Tel: 01895 250230
Case Officer: Michael Gavin
Email: MGavin@hillingdon.gov.uk
Date: 7th September 2021
Our Ref: 51509/PRC/2021/159

RE: Erection of a building for use classes E(g), B2 and B8 along with ancillary development

SITE: Unit 1 Hayes Bridge Retail Park, 1-3 Uxbridge Road Hayes

Proposed Elevations

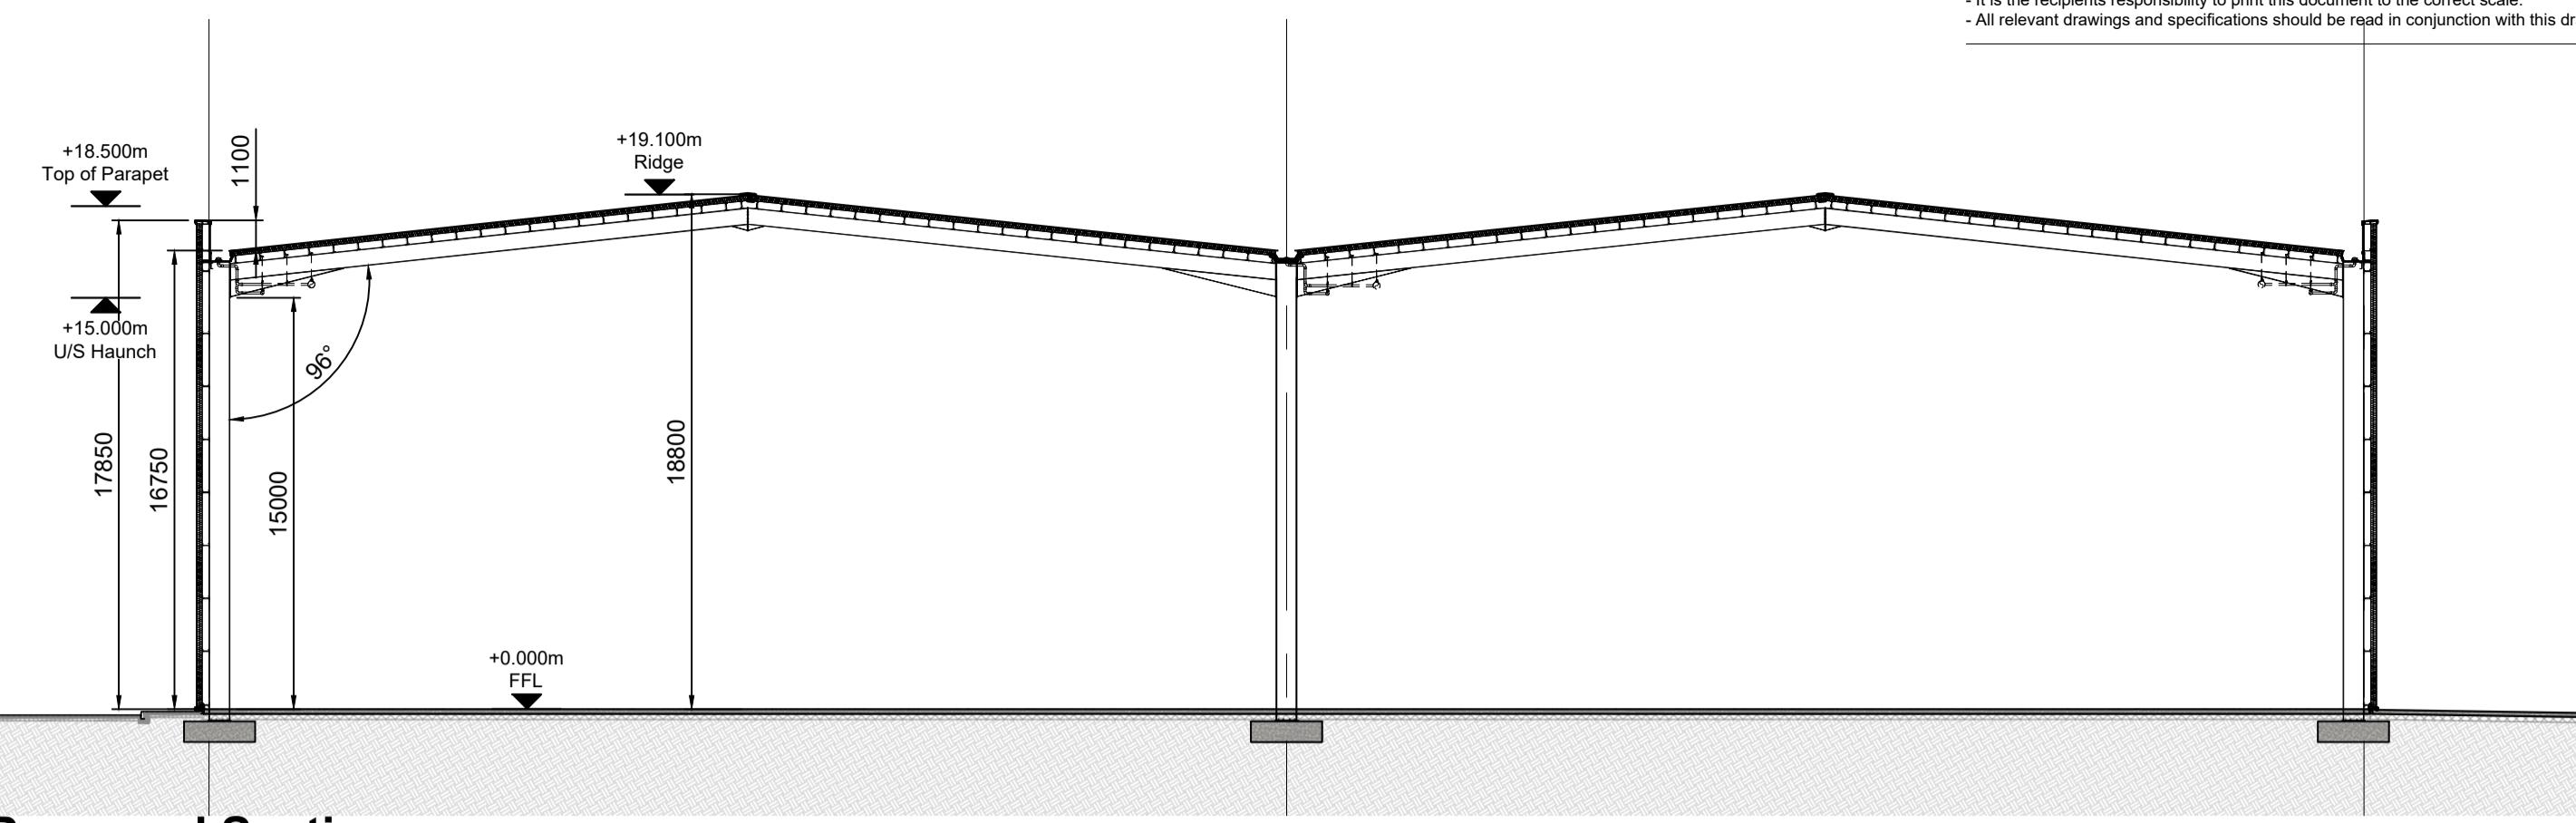
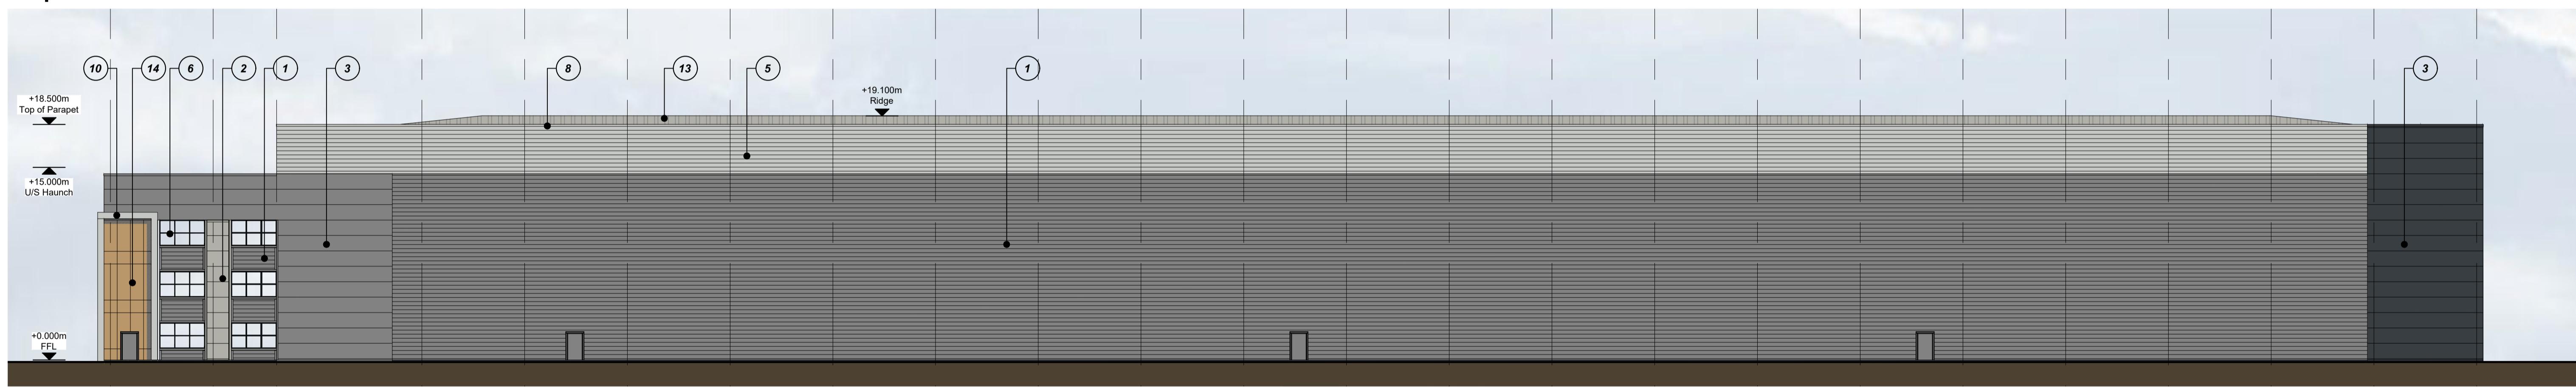
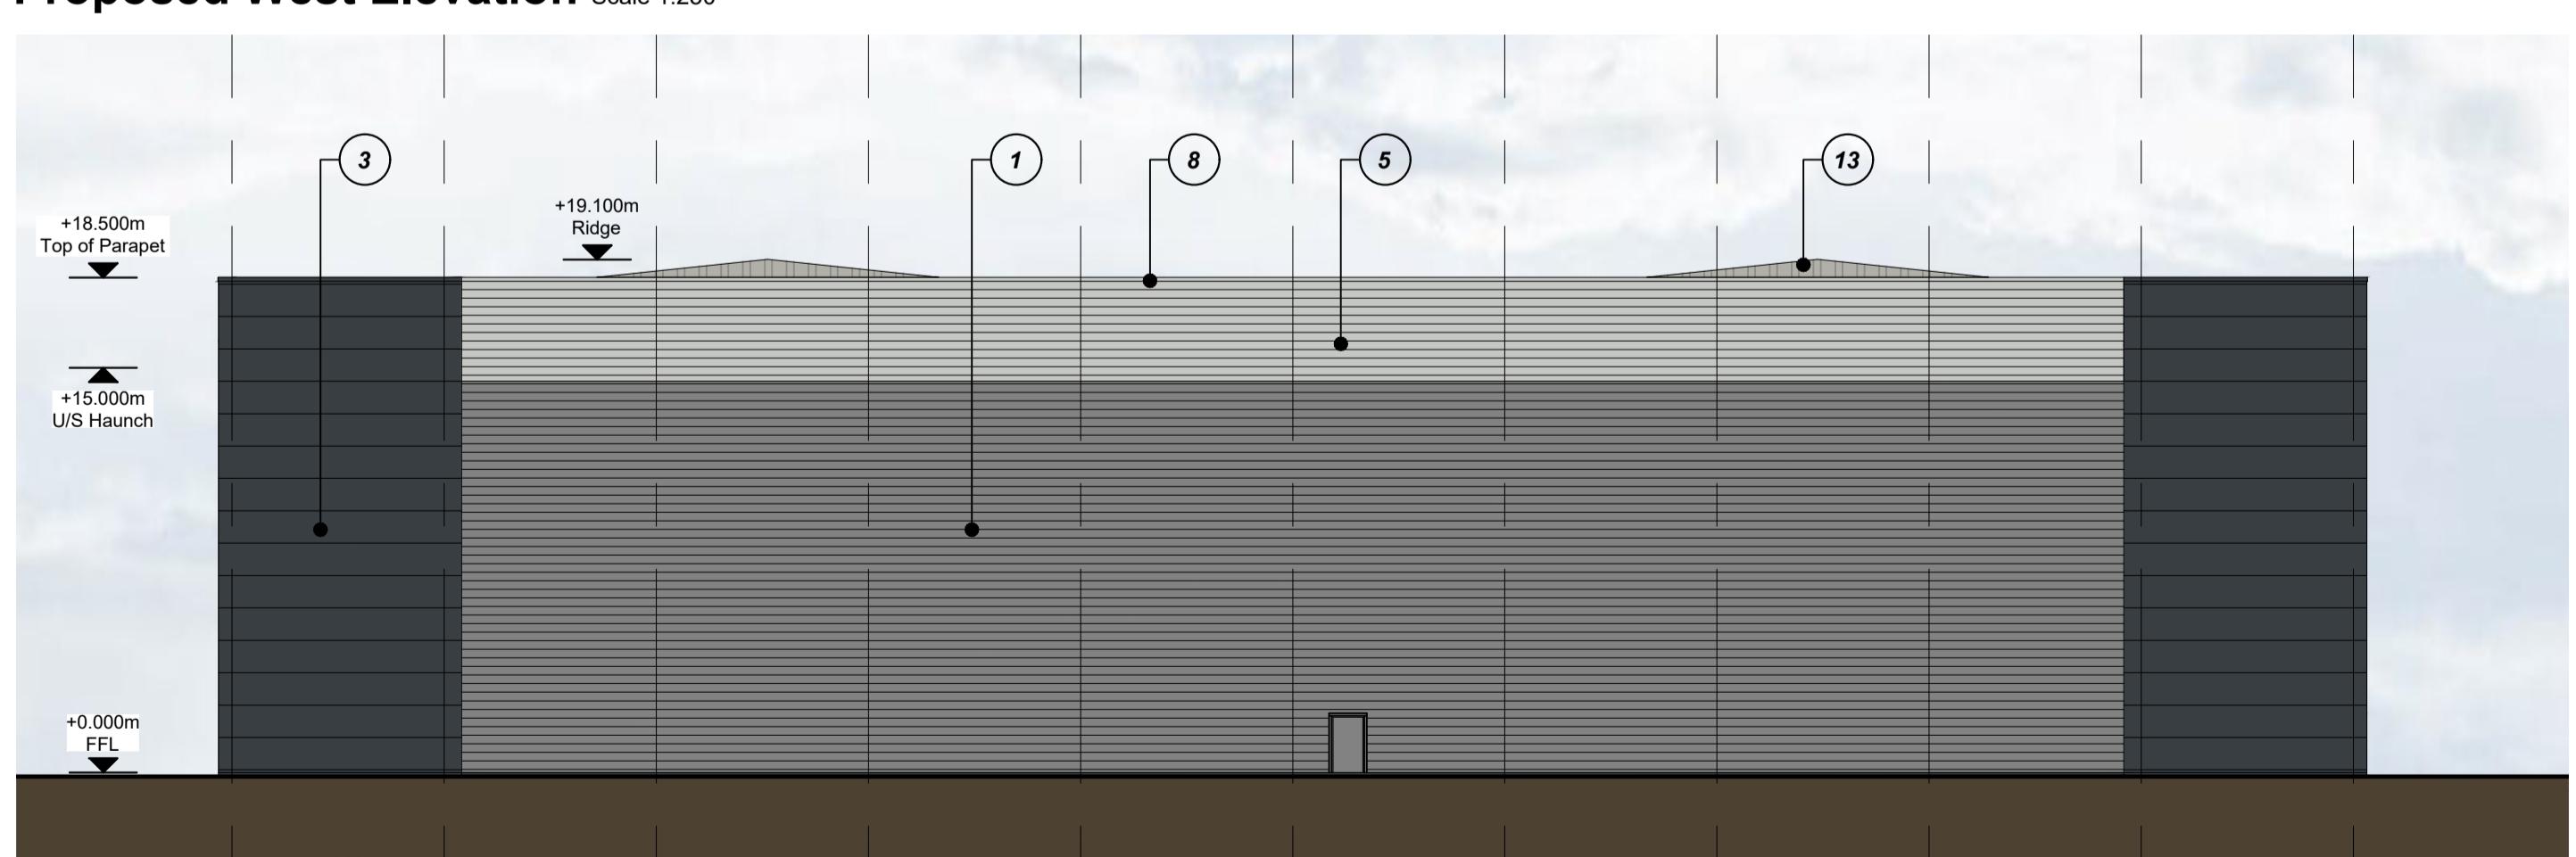
As discussed at our meeting, the existing site is a retail park and pursuant to a retail function the existing buildings are designed to be visible to the public realm. The proposed building is designed for industrial and storage uses and is commensurately larger, higher and more dominant than the existing structures. It is considered that the building and associated hard surfaces should be screened as far as possible to preserve the character and appearance of the street scene and locality.

Given the proposed building's footprint, height, scale and mass, it would be very prominent in the street scene particularly given the wide access and relatively exposed position. The introduction of significant HGV traffic entering and exiting the site onto Uxbridge Road would also be detrimental visually and create a more hostile environment for pedestrians and cyclists. At our meeting we discussed the potential for HGV access to the site to be from the

The materials for the proposed development will need to be carefully selected with a particular emphasis on durable and robust options which will harmonise with the local context, weather attractively and maintain a good appearance in the long term. A Townscape and Visual Impact Assessment would be required to accompany any future application.
